**MODIFICATION REQUEST:
Residential Subdivision
Highview Drive, Dolphin Point
05_0024 MOD 1**

Director-General's
Environmental Assessment Report
Section 75W of the
Environmental Planning and Assessment Act 1979

July 2013

ROAD No.1 -> HIGHVIEW DRIVE

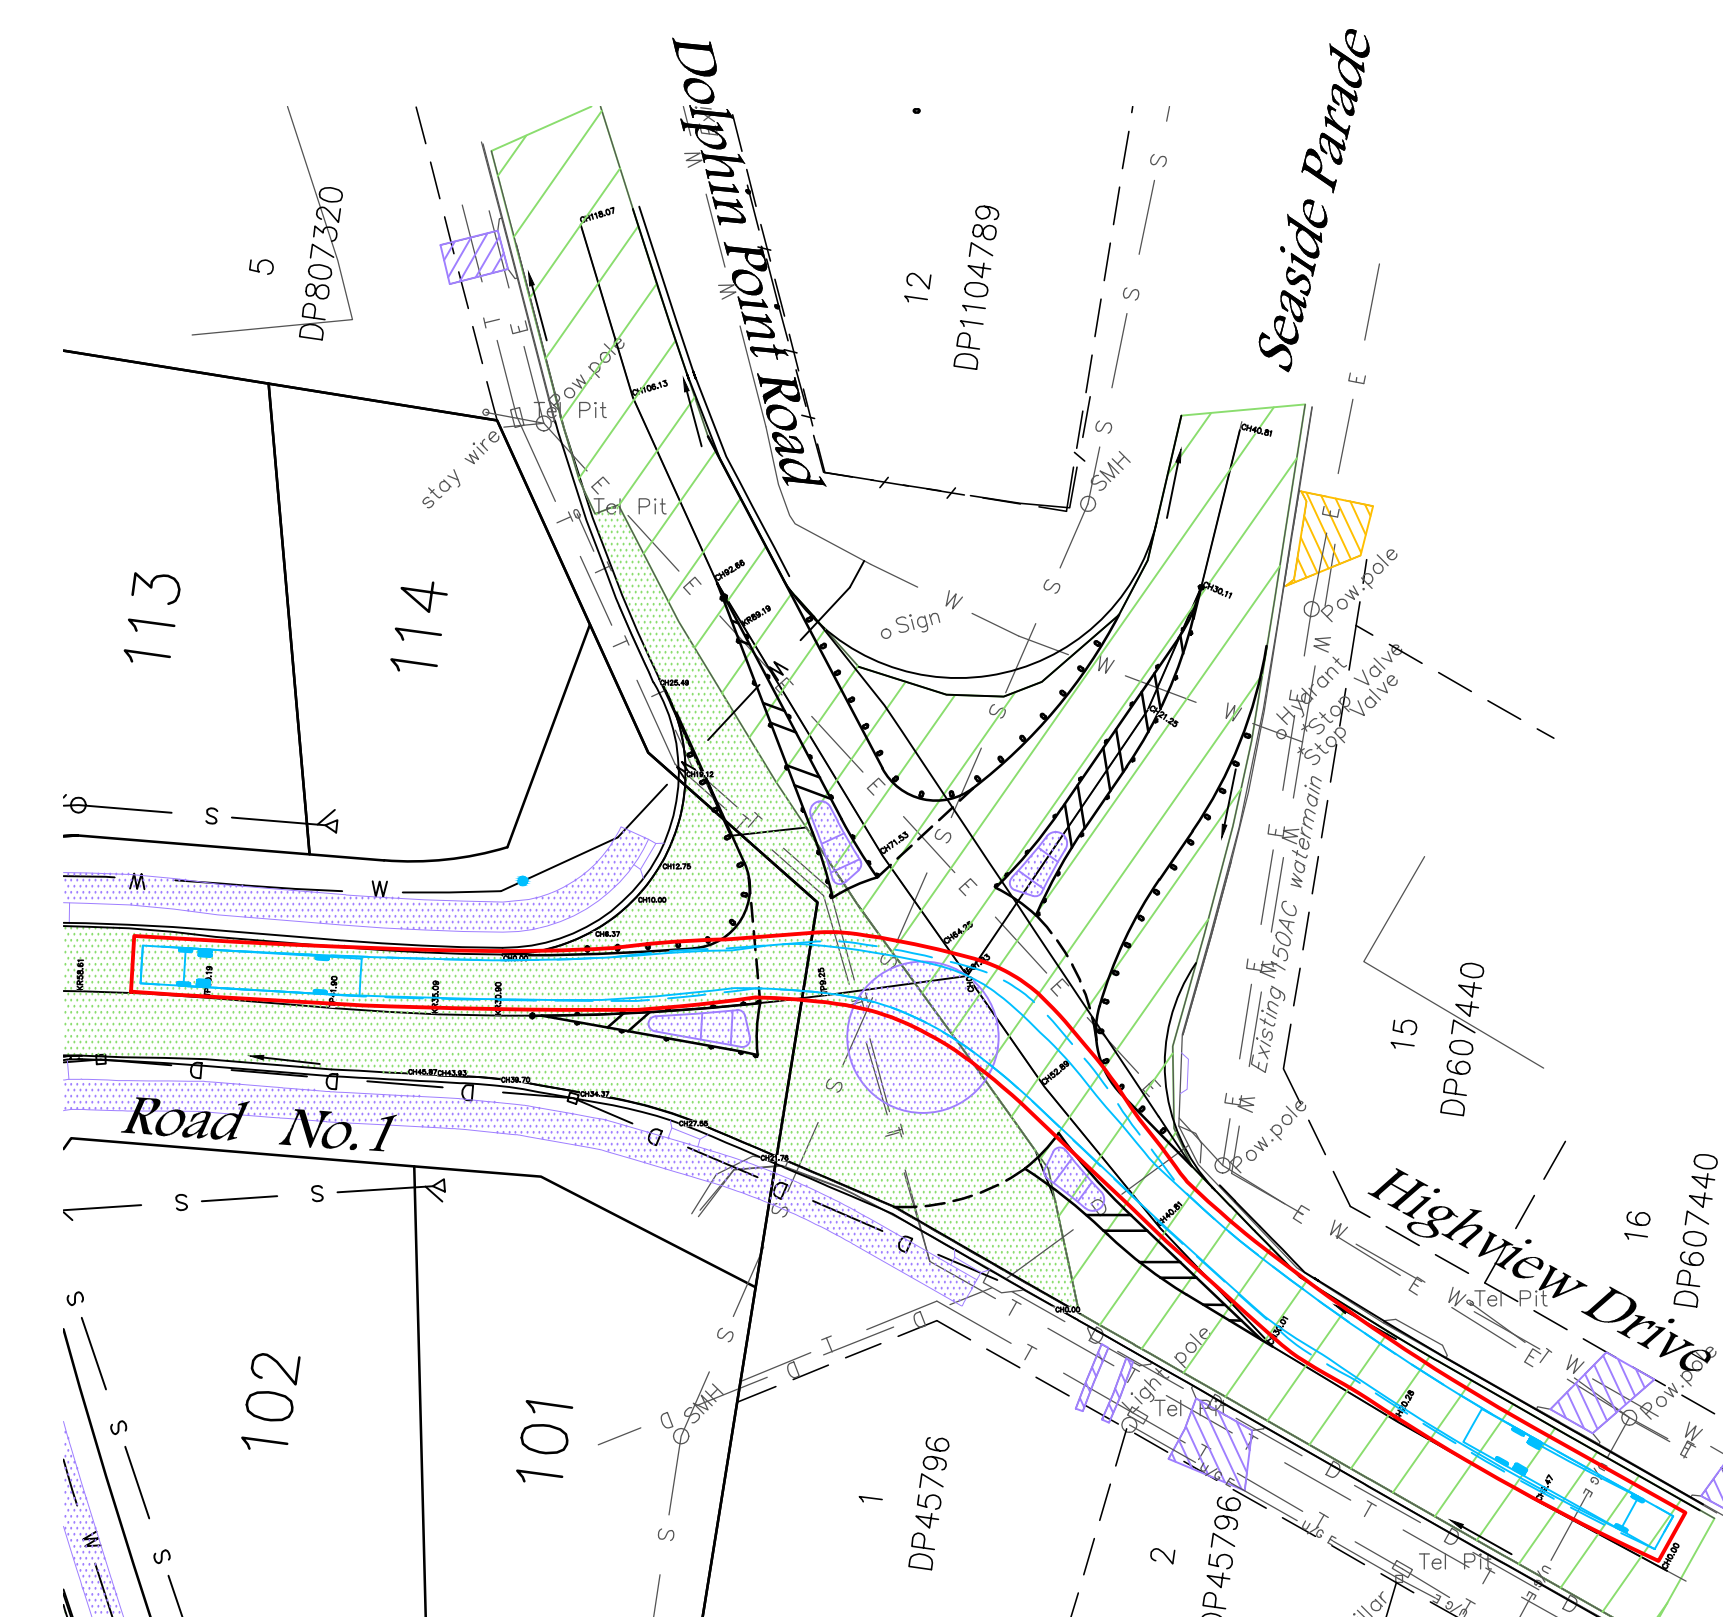
The proponent seeks to modify the design of the roundabout to provide a treatment which fits within the land available. A modified design incorporating a smaller inscribed circle of 22m in diameter with a mountable central island of 10m in diameter is proposed. In support of the modified design, the proponent provided advice from traffic consultants Colston Budd Hunt & Kafes Pty Ltd (CBH&K). CBH&K considered the revised roundabout dimensions were appropriate to cater for the types of vehicles which will use it, and that a larger roundabout at the location was not necessary. CBH&K provided swept path drawings for a 14.5m bus showing that a vehicle of this size will be able to use a roundabout of the size proposed (refer **Appendix C**).

Council objected to the proposed modification of Condition B19(4). Council suggested as an alternative that the final sentence of clause (4) which specifies the dimensions required of the roundabout be deleted. Council considered that the design criteria of the future roundabout will ultimately need to conform to the relevant Austroads standards, and that it is unnecessary to define the detailed roundabout dimensions as part of the condition.

The department concurs with council's advice and considers the future roundabout design and specific dimensions can be agreed upon between the proponent and council at such time the roundabout is to be constructed. This provides the proponent with a degree of flexibility as to the future design of the roundabout. Condition B19(4) is therefore amended to remove reference to the specific dimensions of the roundabout, with the future design of the roundabout to be prepared in consultation with council and in accordance with the relevant Austroads standards prior to the issue of a construction certificate.

PROPOSED RESIDENTIAL SUBDIVISION

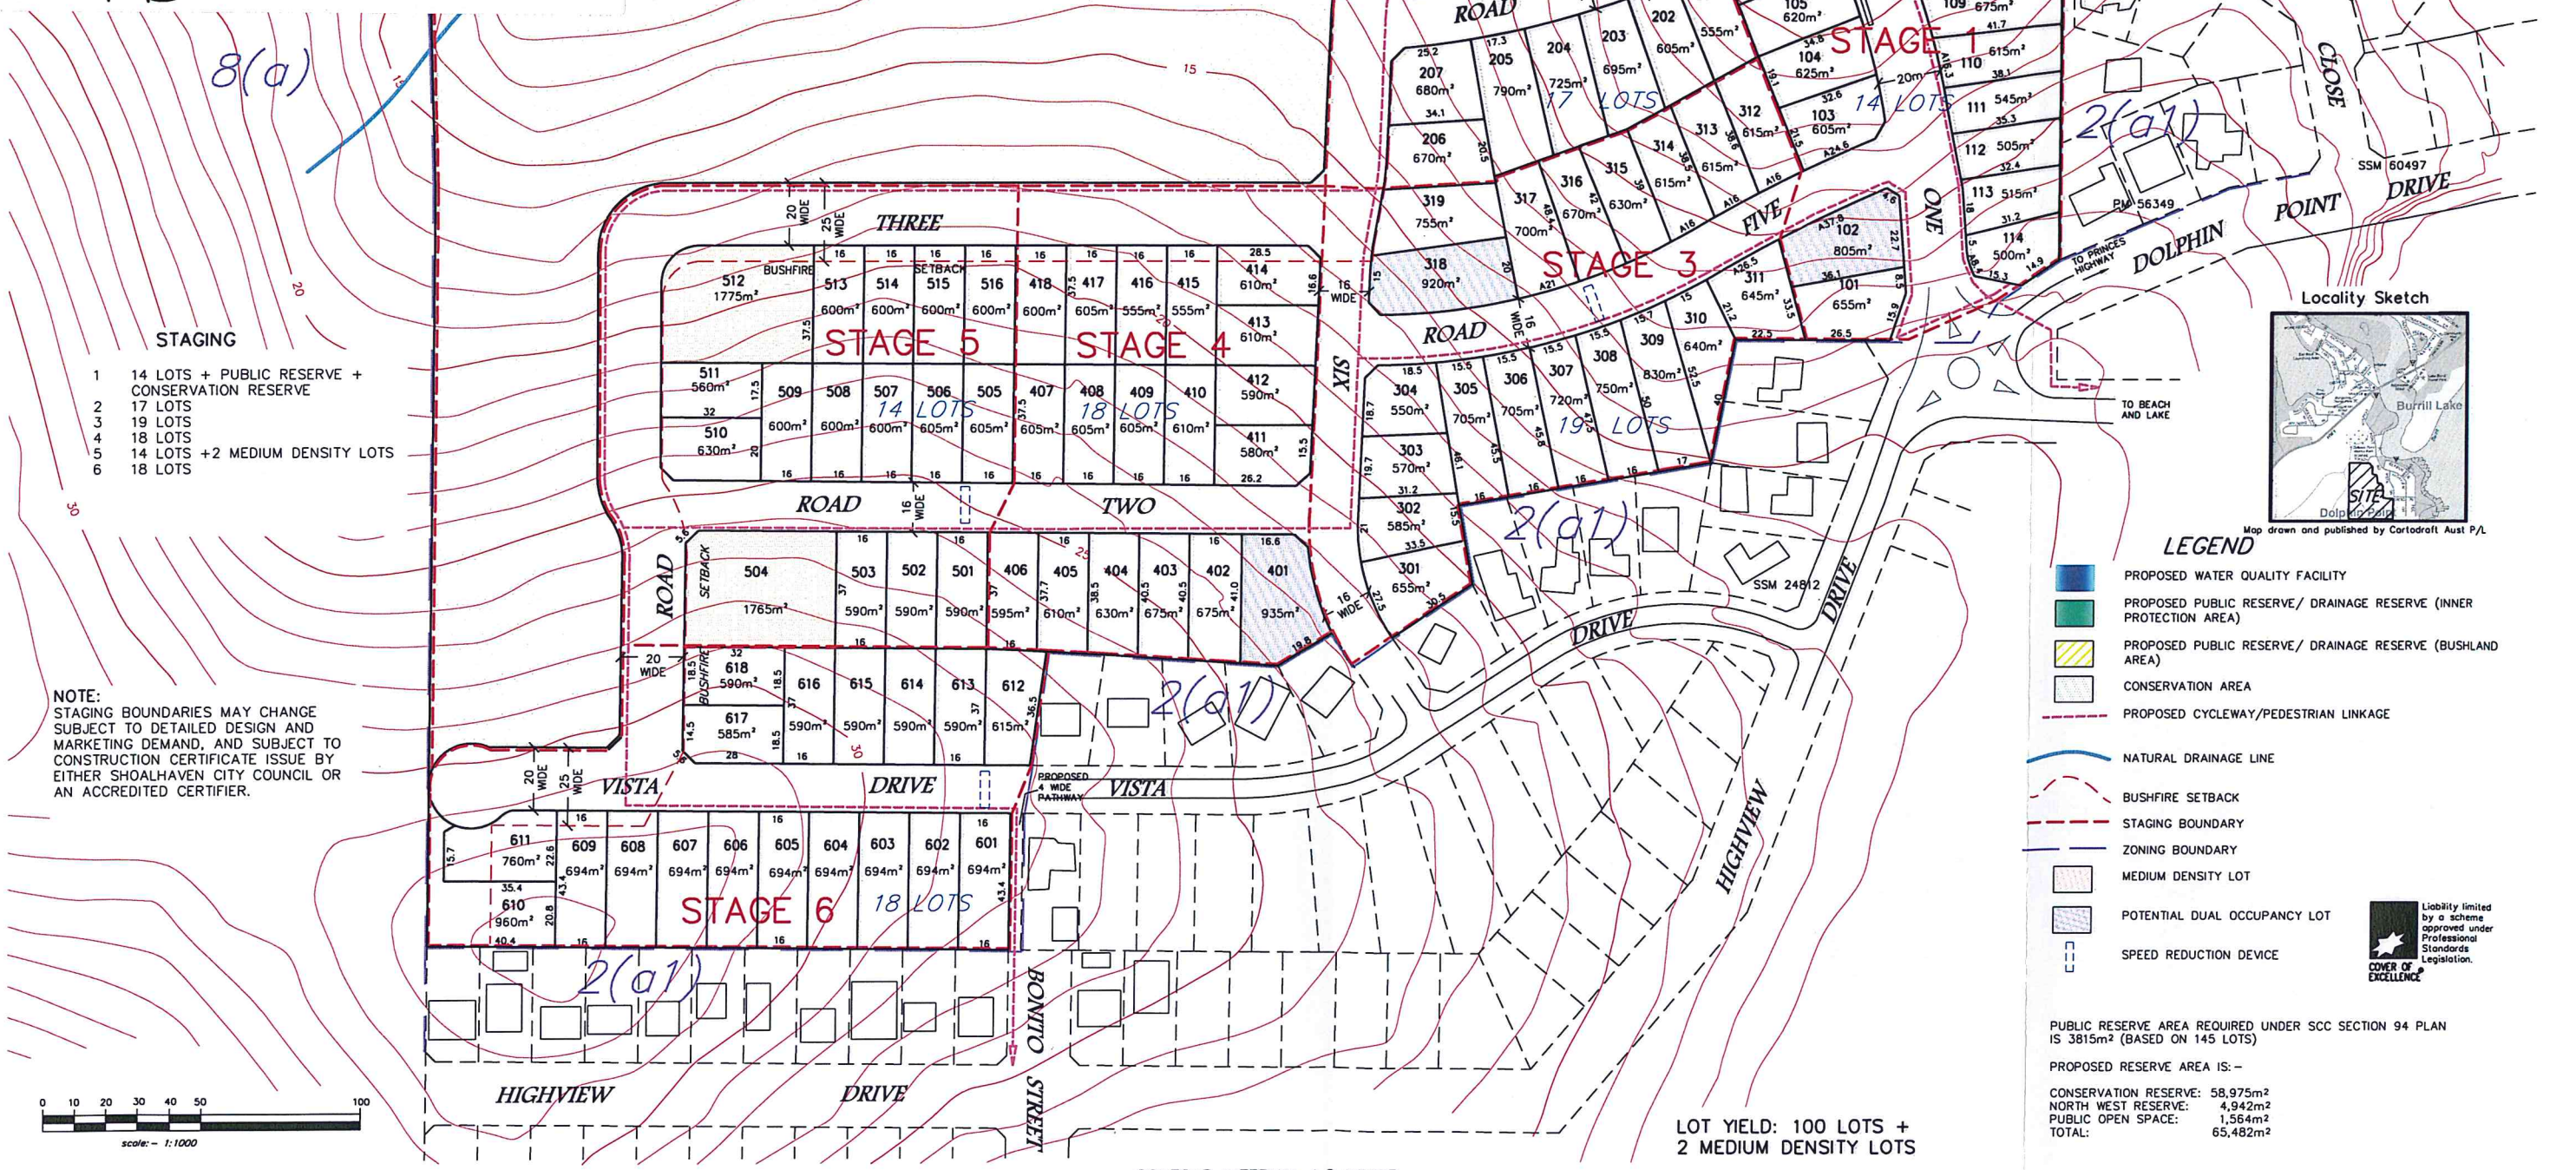
Council notes that the Department issued approval on 8 July 2010 to an amended site plan (Plan: 24163-21-06) submitted by the proponent to satisfy the intention of approval condition B1. The amended plan was not forwarded to Council for comment at the time. The subdivision must retain Road One as the collector road in the network.

The road layout reduces the effectiveness of Road One being the collector road leading to the proposed Highview Drive / Dolphin Point Road controlled intersection. This road is also part of the proposed bus route. The orientation of Road Six will appear to be the collector road function leading vehicles from the approved residential subdivision of land to the west and the lots within the subject subdivision via Vista Drive to Highview Drive. The intersections of Road 6 and Vista Drive and Vista Drive at Highview Drive have not previously been assessed with any upgrades being incorporated into conditions of approval.

The design treatments within the road reserve at the intersection of Road One and Road Six will be required to provide an offset treatment that is to be approved by Council as part of the construction plans.

The section of Road Six adjacent to the lots 301 and 401 should be treated with traffic slow down design that is to be approved by Council as part of the construction plans.

The layout concept is generally as previously discussed however it is necessary to define criteria for the lot 108 frontage width to Bonnie Doon Close. Lot 109 (DP 817218) Bonnie Doon Close has its private driveway crossing that is to remain untouched by any proposed access driveway to serve Lot 108. Therefore the width of Lot 108 fronting Bonnie Doon Close must be at least 10m so an independent vehicle crossing can be provided into Lot 108 as part of a future dwelling development. An aerial photograph of the affected lots is shown in Appendix 2.
